Cherwell District Council: Begbroke Science Park, Begbroke Hill, Begbroke, Kidlington, OX5 1PF

On behalf of our client, Oxford University Development Ltd (OUD), please find enclosed an application for a Non-Material Amendment (NMA) to Reserved Matters Approval (Ref. 21/03150/REM) (dated 27 January 2022) for:

Proposed Amendments

BBSP-NBBJ-ZZ-XX-DR-A-503011

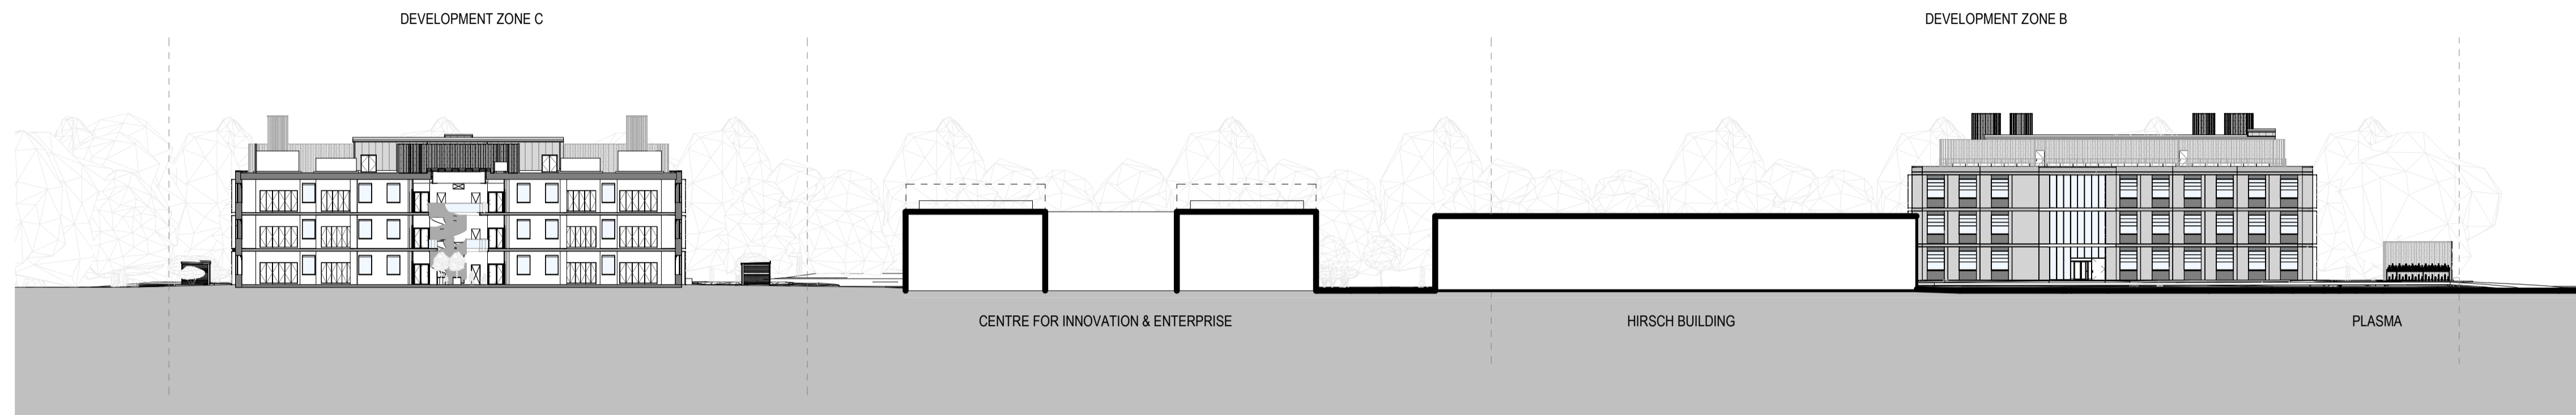
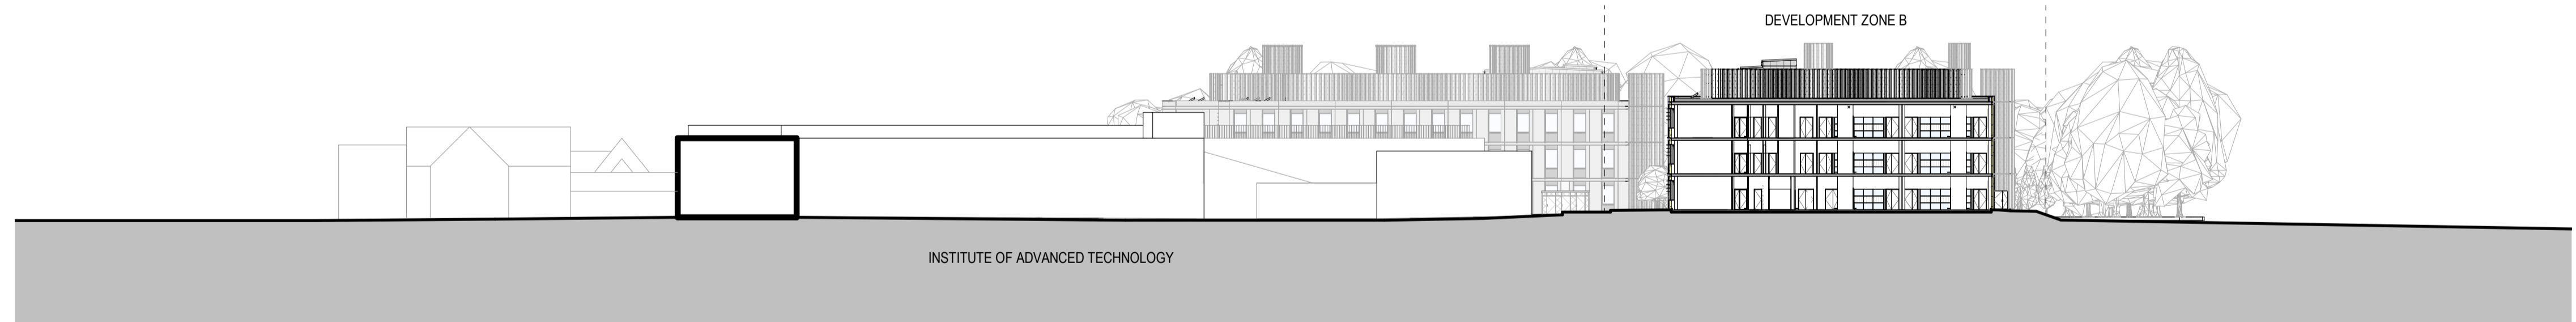
As OUD has progressed with the detailed design of the reserved matters approval it has become apparent that there is a need for several flues on the roof of the academic building rather than one single central flue. The flues required would be 300 mm higher in height than those previously approved.

Drawing
Proposed Section AA

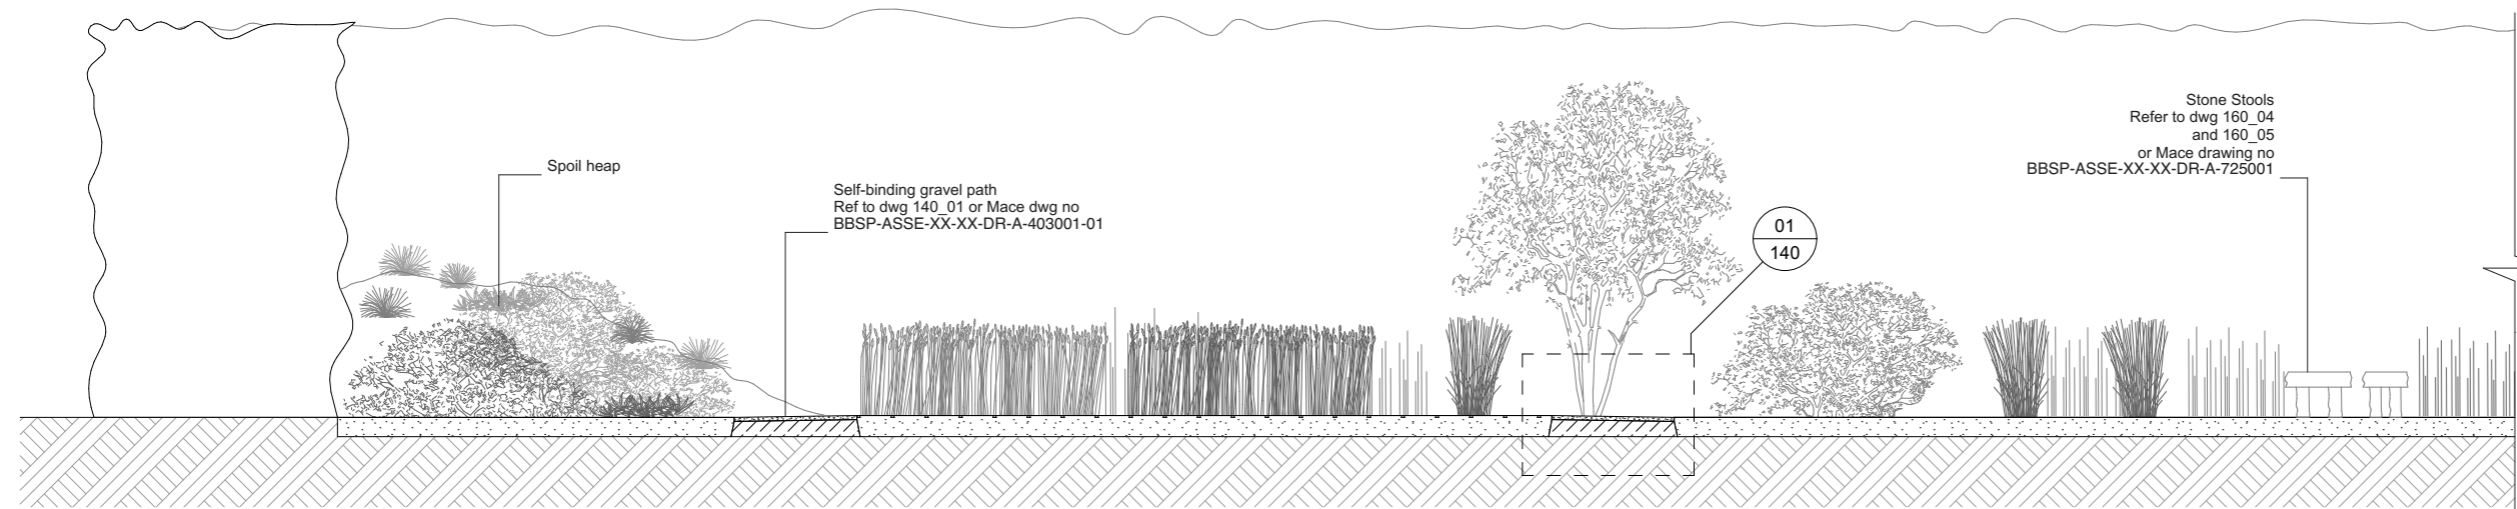
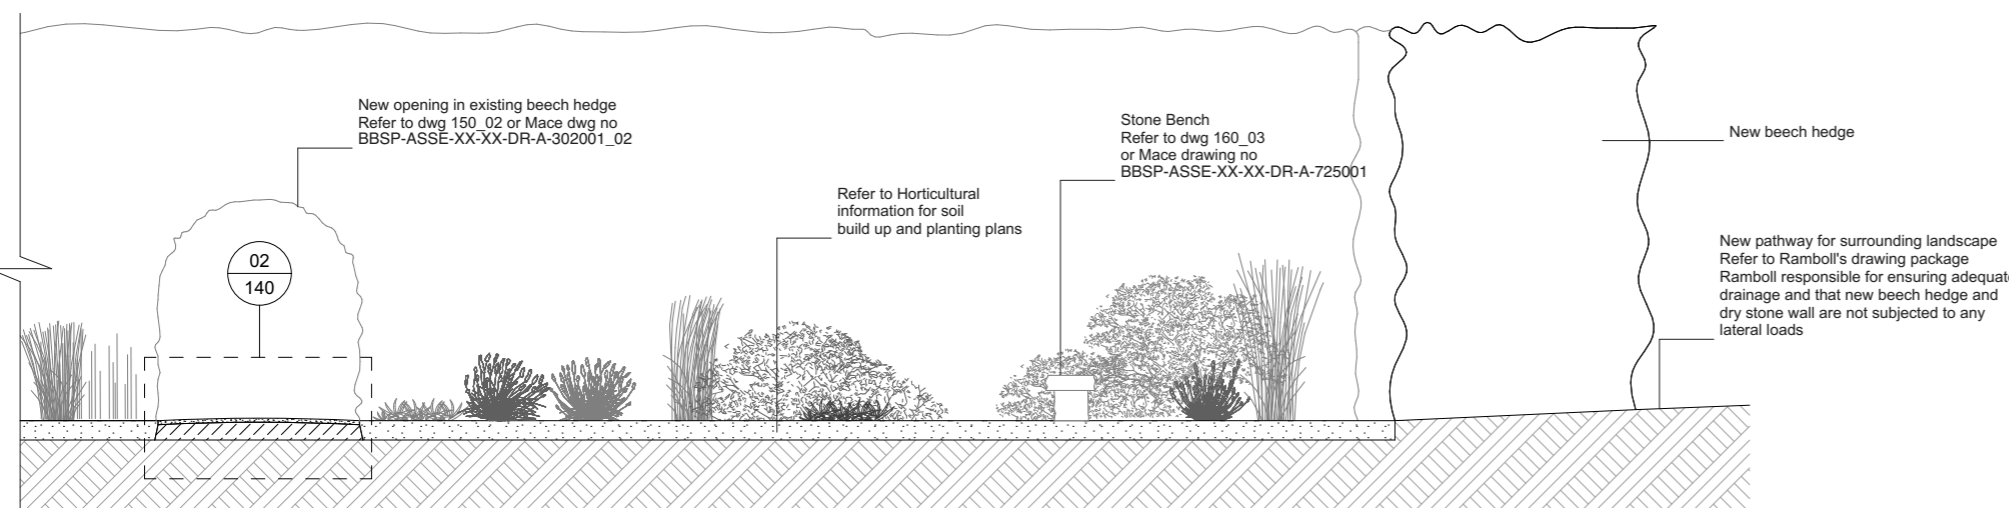
In addition to the above, the design for the Weed Garden at Begbroke has changed from the Reserved Matters application in responding to the design development of the wider Begbroke scheme. Due to an identified level change of 280mm on the eastern side of the site, a gentle ramp from the east into the site is now required. As a result of the new ramp, access to the sink and events area in the north east of the site is more complex. In response to this, the sink and events area has been relocated to the south eastern part of the site by the proposed dry stone wall for improved level access and to be closer to the main entrance to the garden. The spoil mound in the south eastern corner has also been re-moulded around the ramp to absorb the level change. Lastly, the material for the main access path through the centre of the site has changed from Colas Fibredec to stone crazy paving.
